From: Anita Gardner <Anita.Gardner@arun.gov.uk>
Sent: 05 October 2020 13:08
To: Planning.Responses <Planning.Responses@arun.gov.uk>
Subject: FW: F/21/20/DOC Wicks Farm

I have summarised my comments below in respect to the outstanding issues;

The following link will allow a download of the drawings as noted on the attached drawing issue register together with the updated Reservoir Calculations and Management and Maintenance Plan. For ease of reference I have noted our responses in green below to the latest comments.

A	24.09.20	PR	Ditch widths and bank gradients added.	SB
REV	DATE	INT	DESCRIPTION	CHK

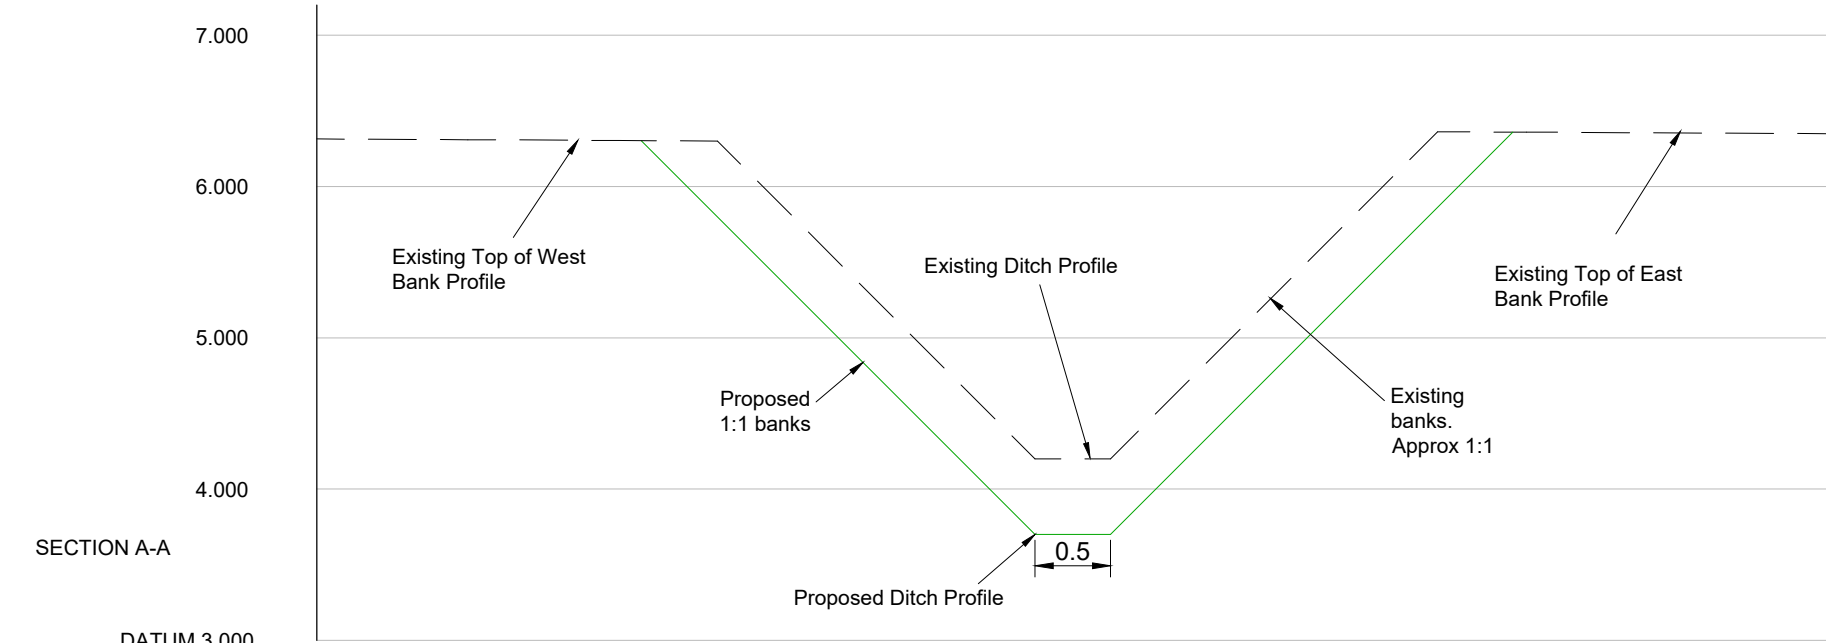
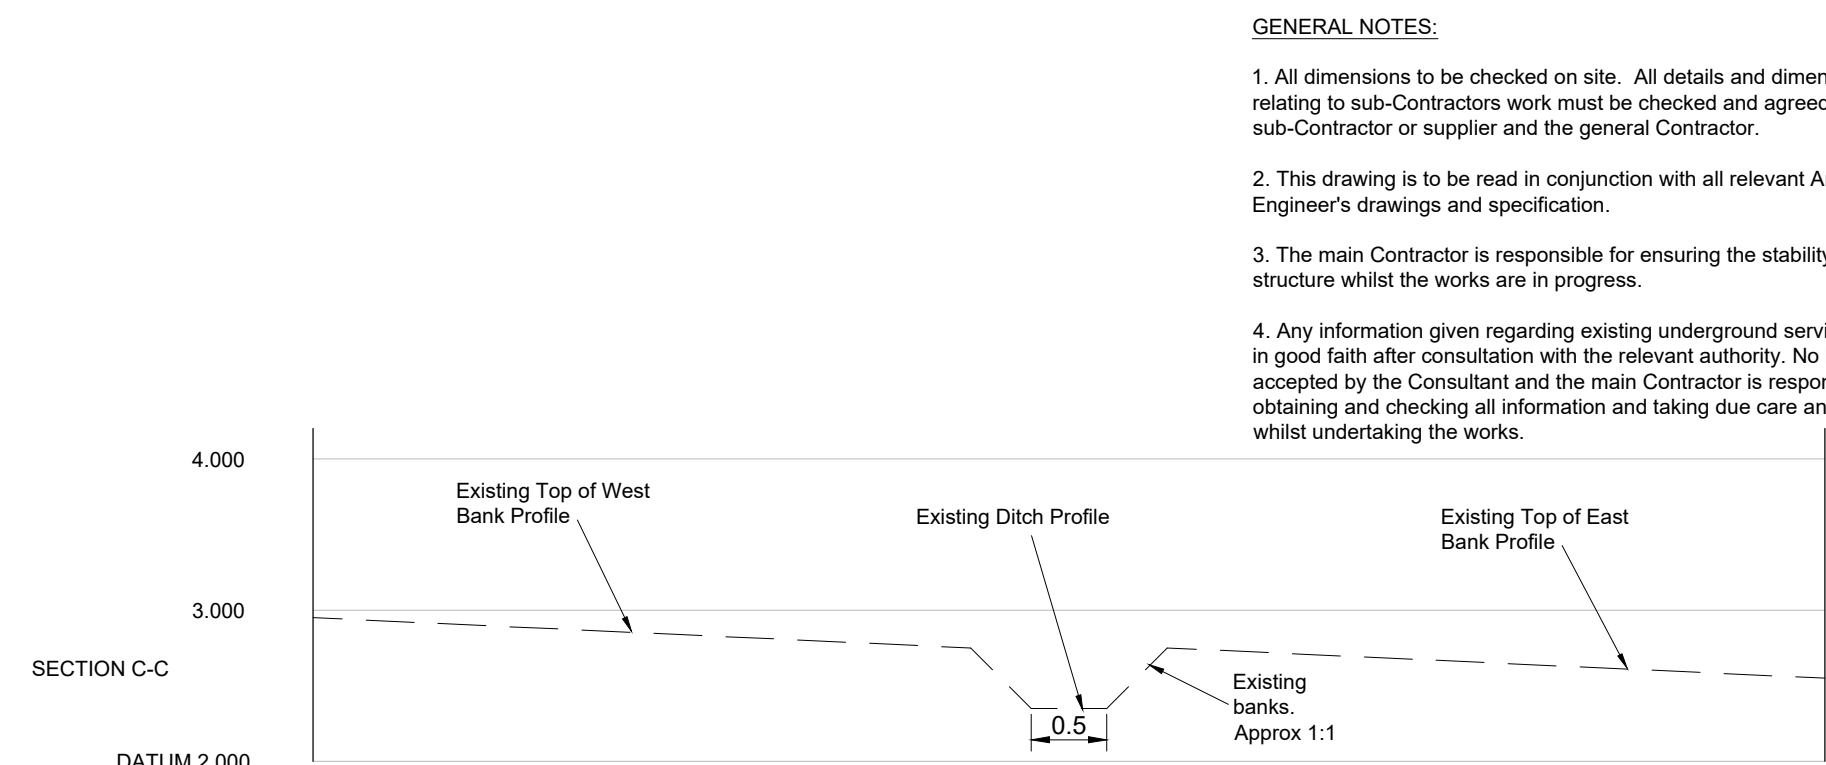
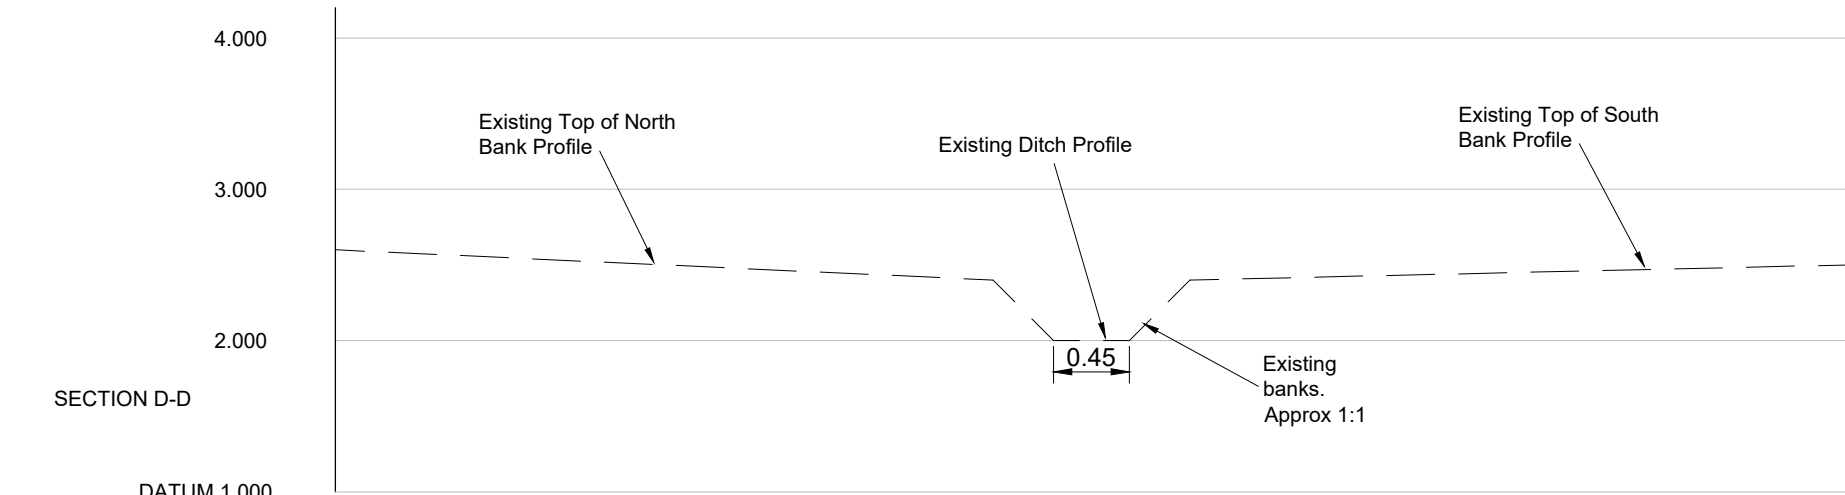
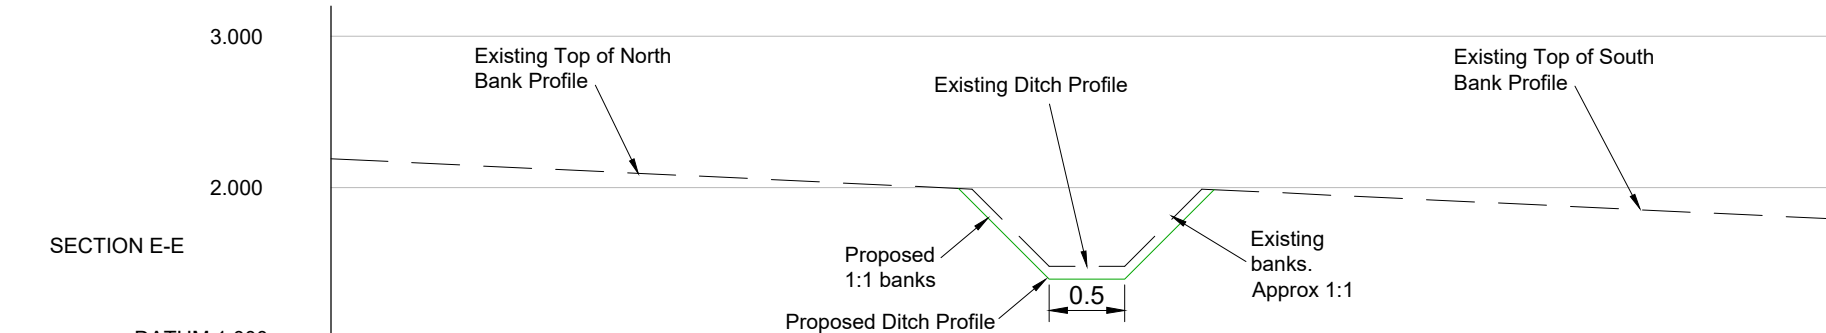
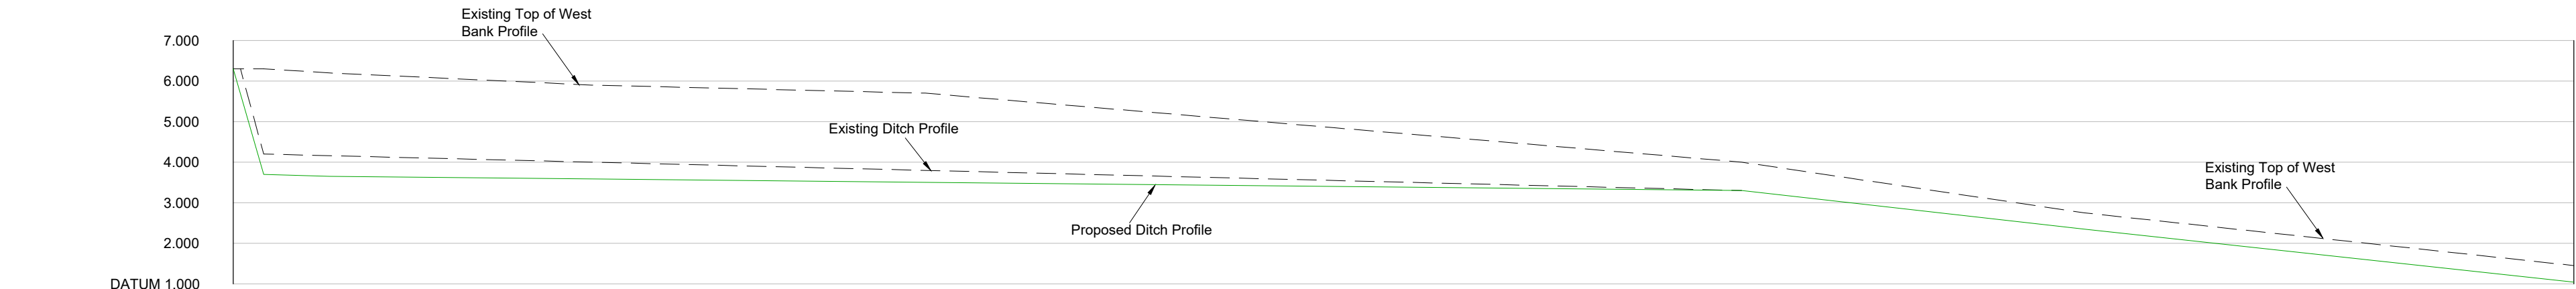
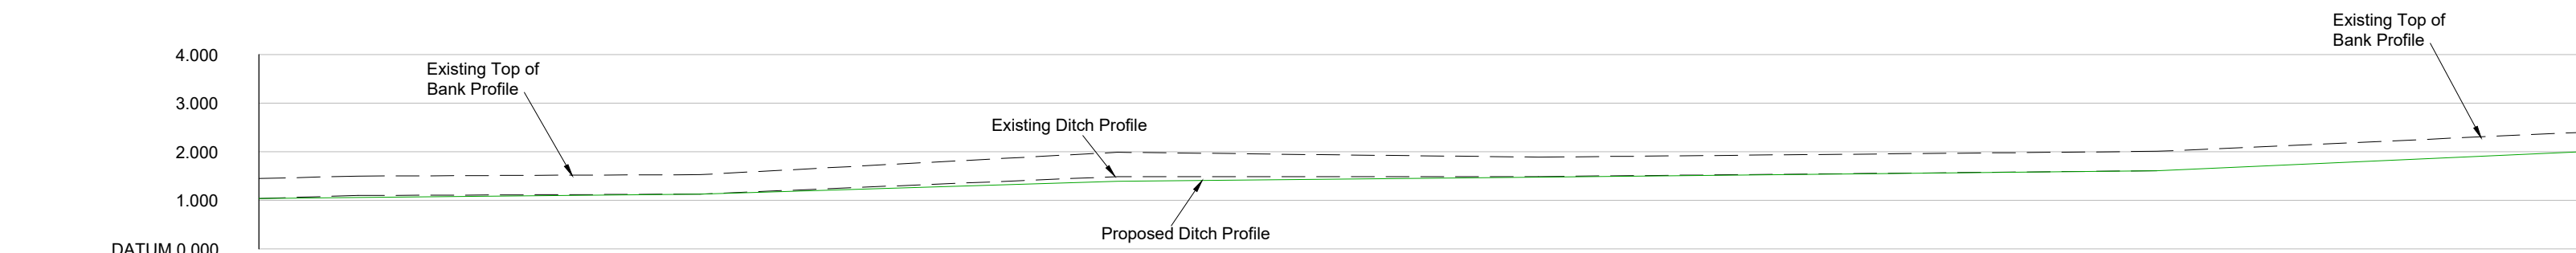
1. The northern boundary ditch in vicinity of the proposed reservoir is currently located on the other side of the network rail fence and not within the redline boundary. As previously suggested a ditch will be required within the red line boundary and running parallel to the network rail ditch. Please adjust drawings and provide a typical profile cross section. Land drainage consent is also required for the new ditch and headwall outlet. There is an existing ditch on site at the northern boundary and a further ditch the other side of the Network Rail fence, the existing ditch is noted to be cleared of debris, vegetation and silt and regraded where required. This is indicated on drawings 21E, 22E and 24E. The comments on Land Drainage Consent are noted but are not a reason to refuse discharge of condition as they are covered by separate legislation. My last visit to site indicated that there was no obvious ditch in vicinity of the reservoir, apart from the one on the other side of the Network Rail

fence, however, provided the ditch is installed as per the drawings then this is not an issue. On the cross sections ie. D-D and E-E, clearly indicate the ditch base width and the gradient of the side slopes. Land drainage consent is an integral part of the outstanding conditions ie. no.8, and in this instance, I am prepared to allow the consent to be just made for the headwall structure/discharge – please therefore submit as necessary. Noted. The ditch base and bank gradients have been added to all sections A-A to E-E. See Drawing 70. Ok
